From: Martyn White
Sent: 08 July 2019 11:38
To: Planning.Responses <Planning.Responses@arun.gov.uk>
Cc: Anita Gardner <Anita.Gardner@arun.gov.uk>
Subject: AB/50/19/PL

AB/50/19/PL

Proposed part change of use (Class C3a) to form a single residential unit from two existing separate buildings. One building currently mixed use (part C3a & part A1) & the other residential (class C3a). Limited external works demolition boundary wall & external stairway

PROPOSED FLOOR PLANS

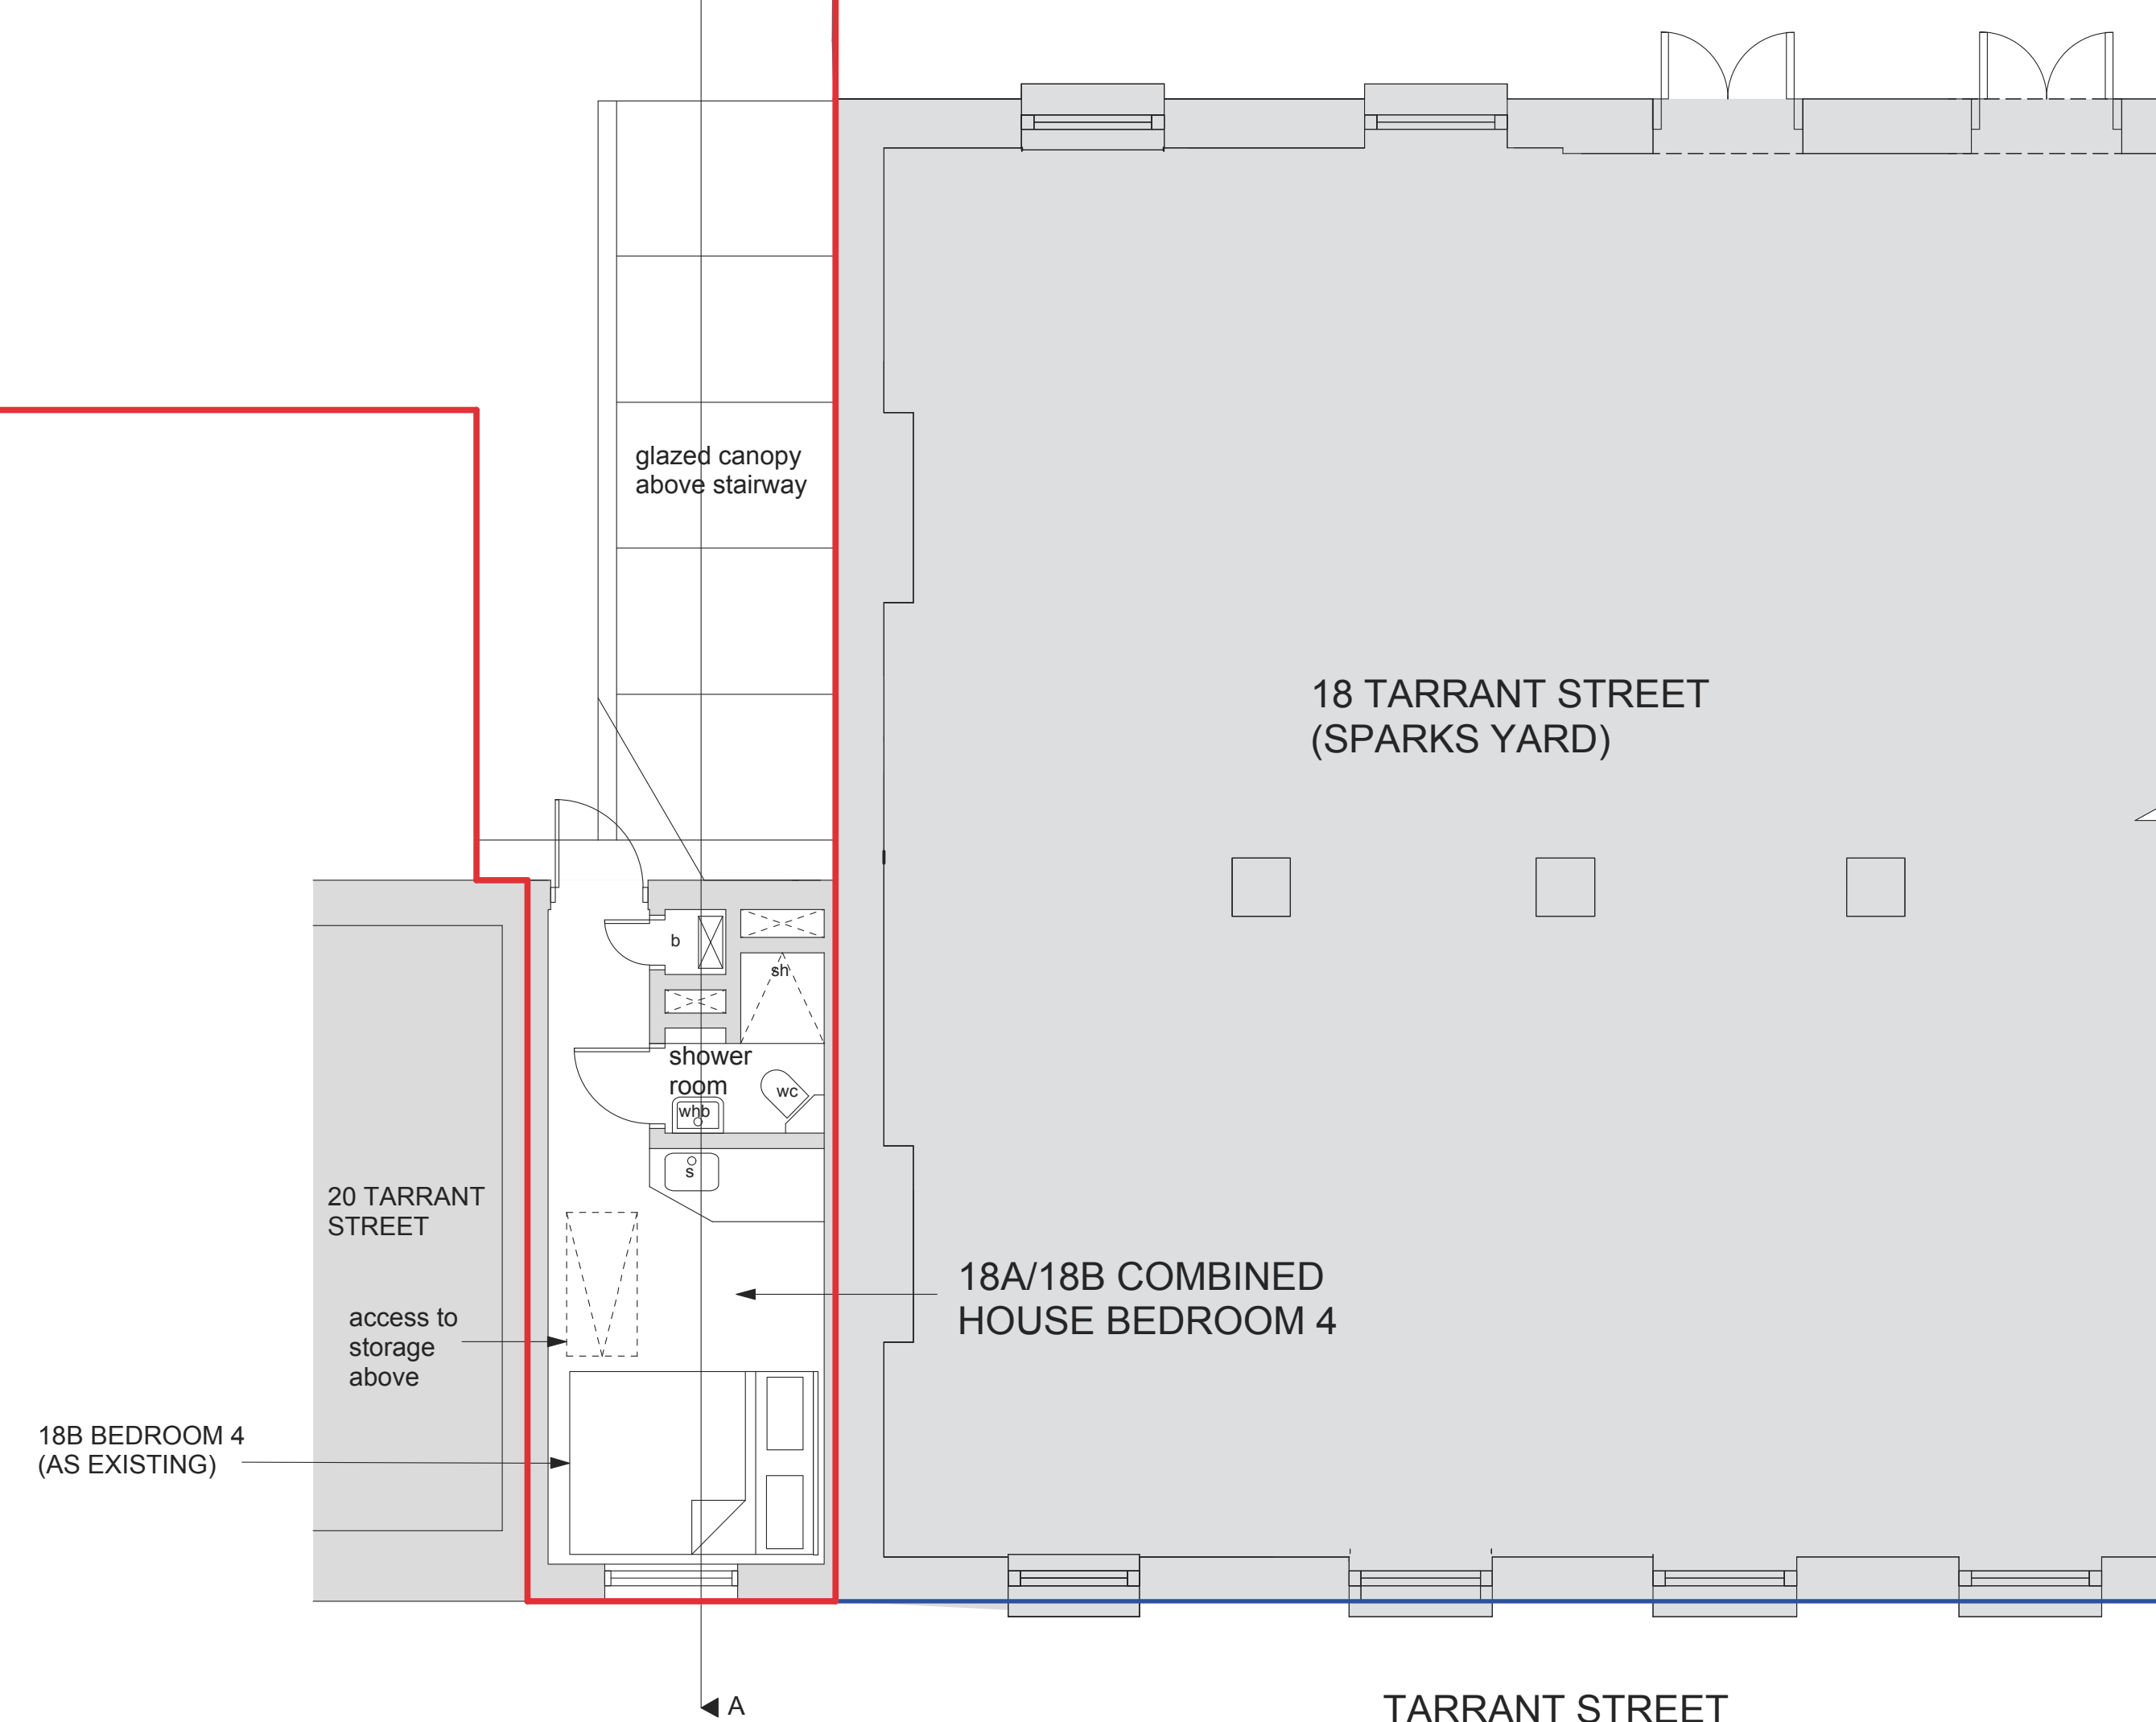
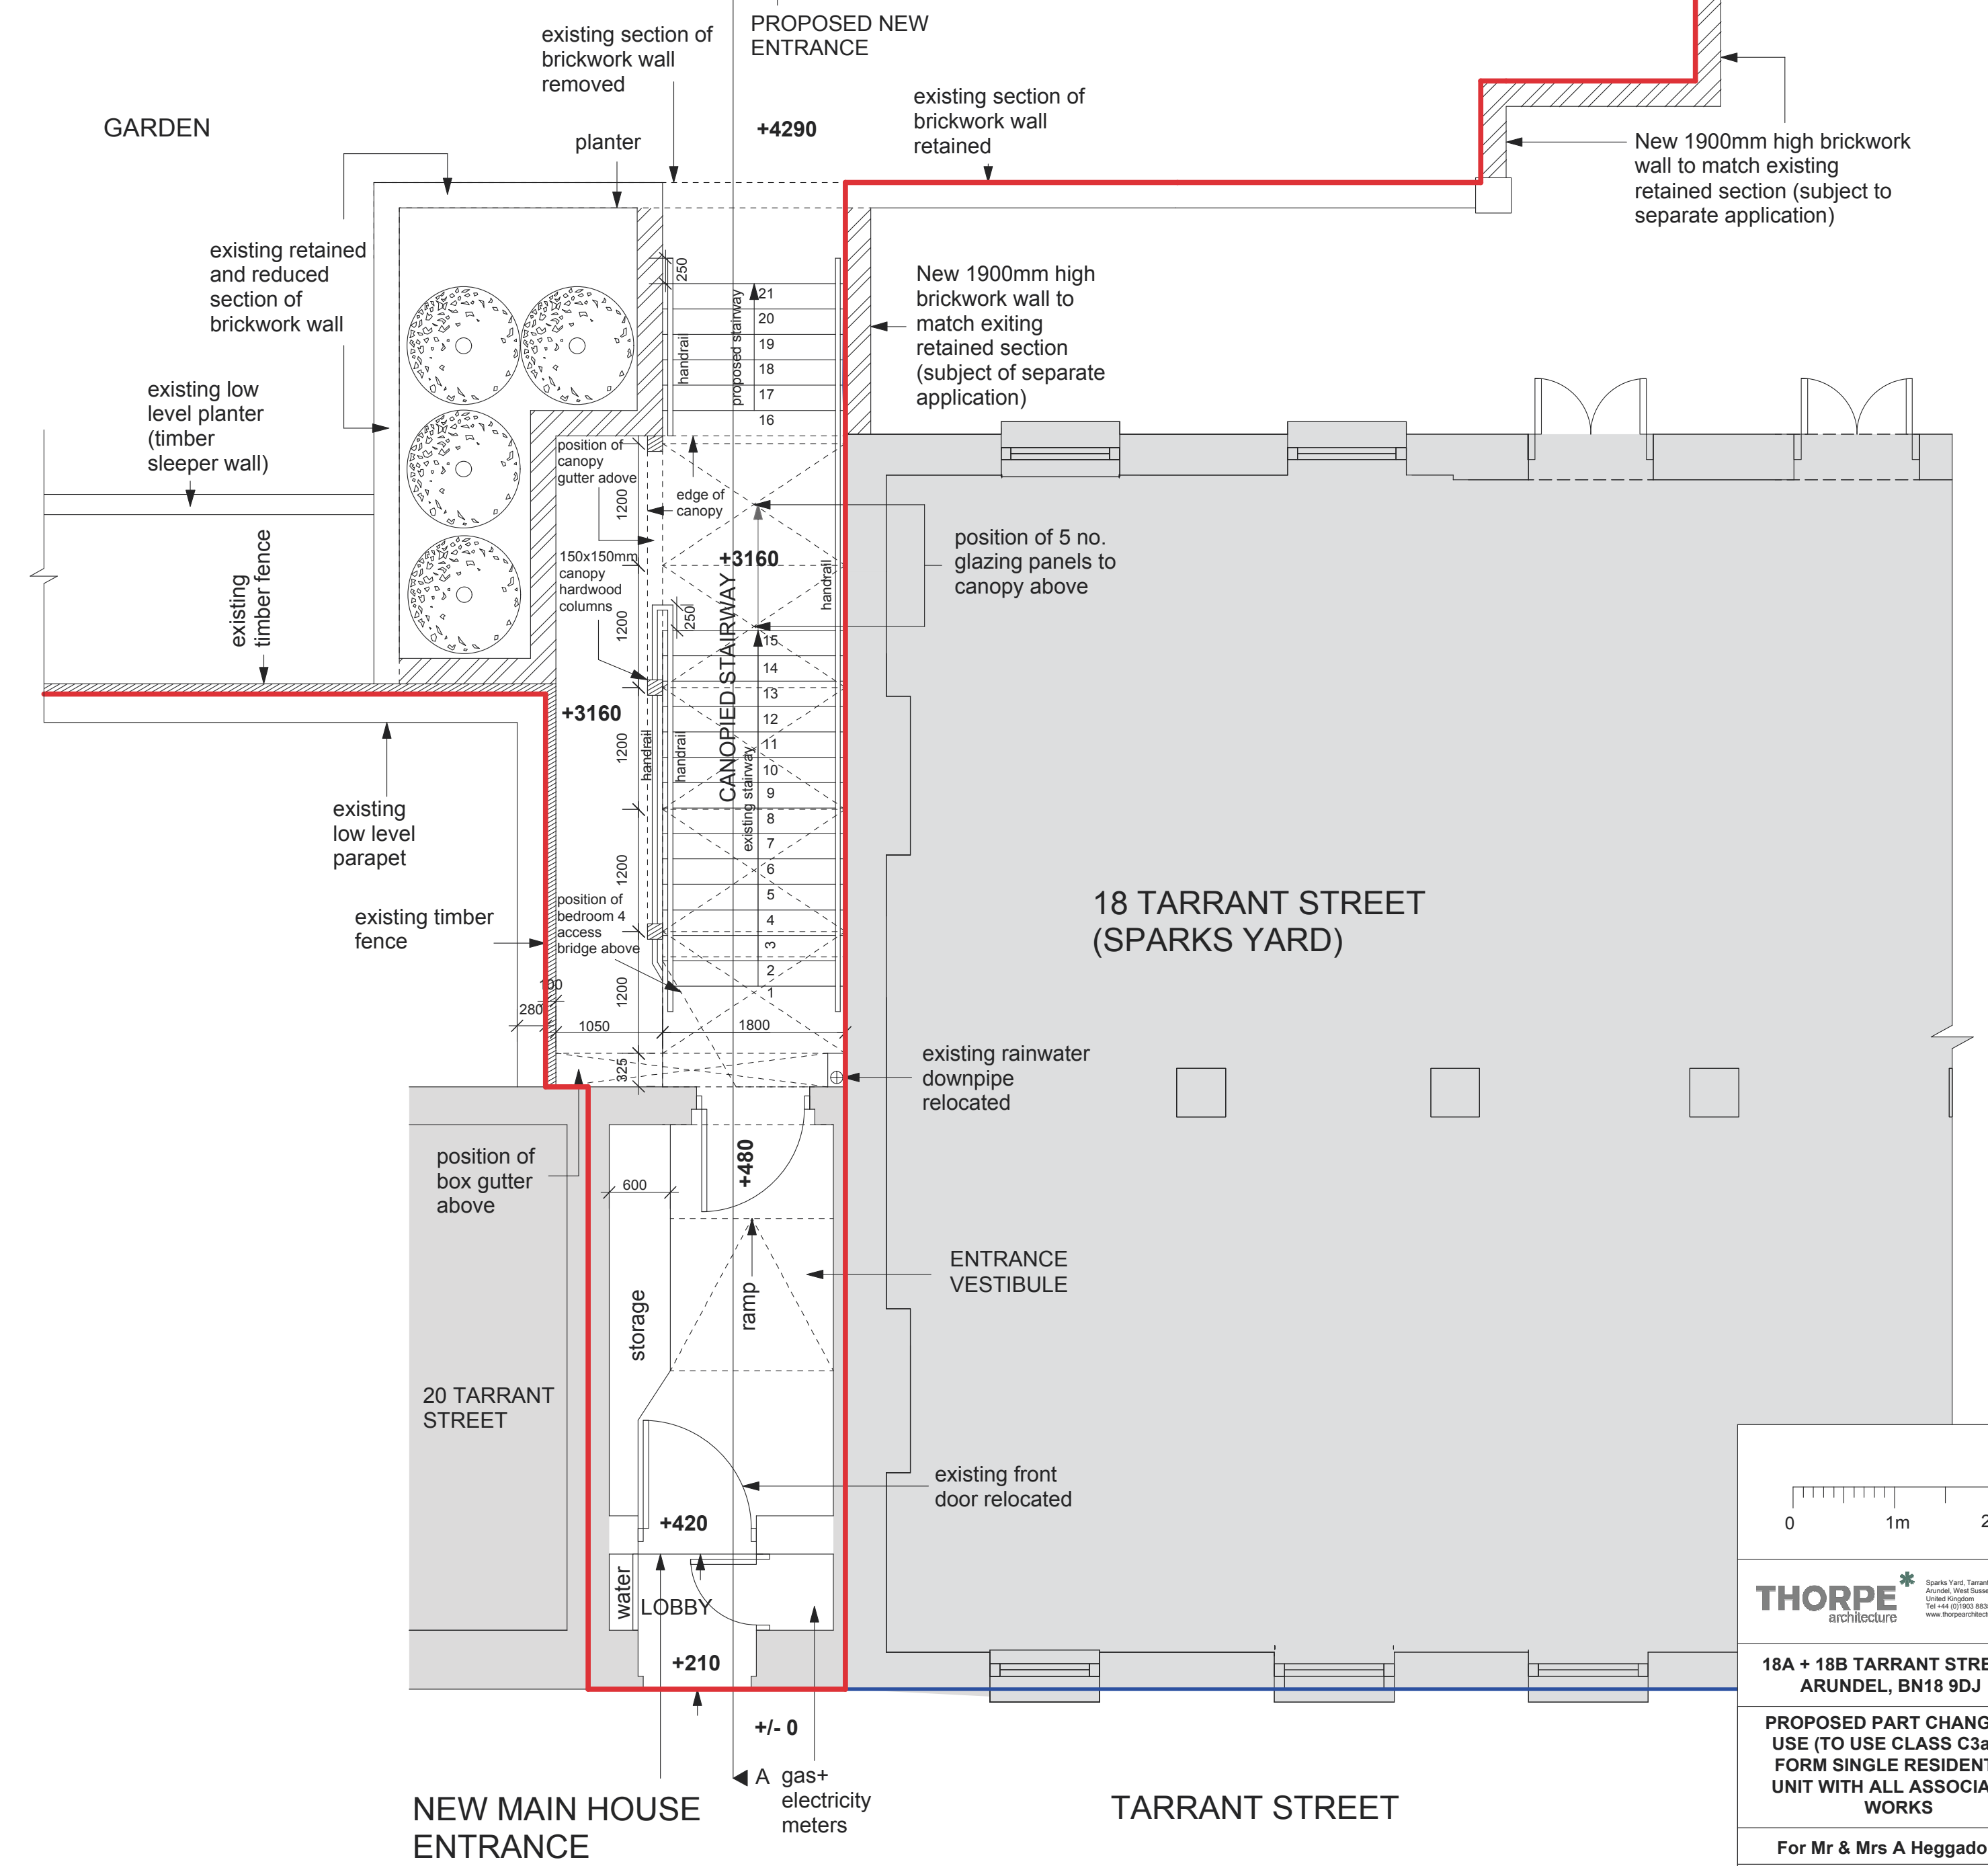
Whilst this is unfortunate, it is acknowledged that the reason behind this is to ensure that a suitable use will be achieved for the property. It is suggested that the proposed brickwork which would be used to infill the windows/door should be slightly recessed so that the former openings can be read and understood as a development of the building. All brickwork and mortar should match the existing in terms of appearance and bond. It is suggested that the bricks removed to create a new opening for the new main entrance could potentially be used for this purpose, if considered to be suitable/match those used in the elevation.

The proposed new opening is considered to be acceptable as the amount of historic fabric to be removed is minimal and will not affect the significance of the building. It is suggested that these bricks are retained and used on the eastern elevation where existing openings are to be blocked up. The design of the door will need to be approved by the LPA.
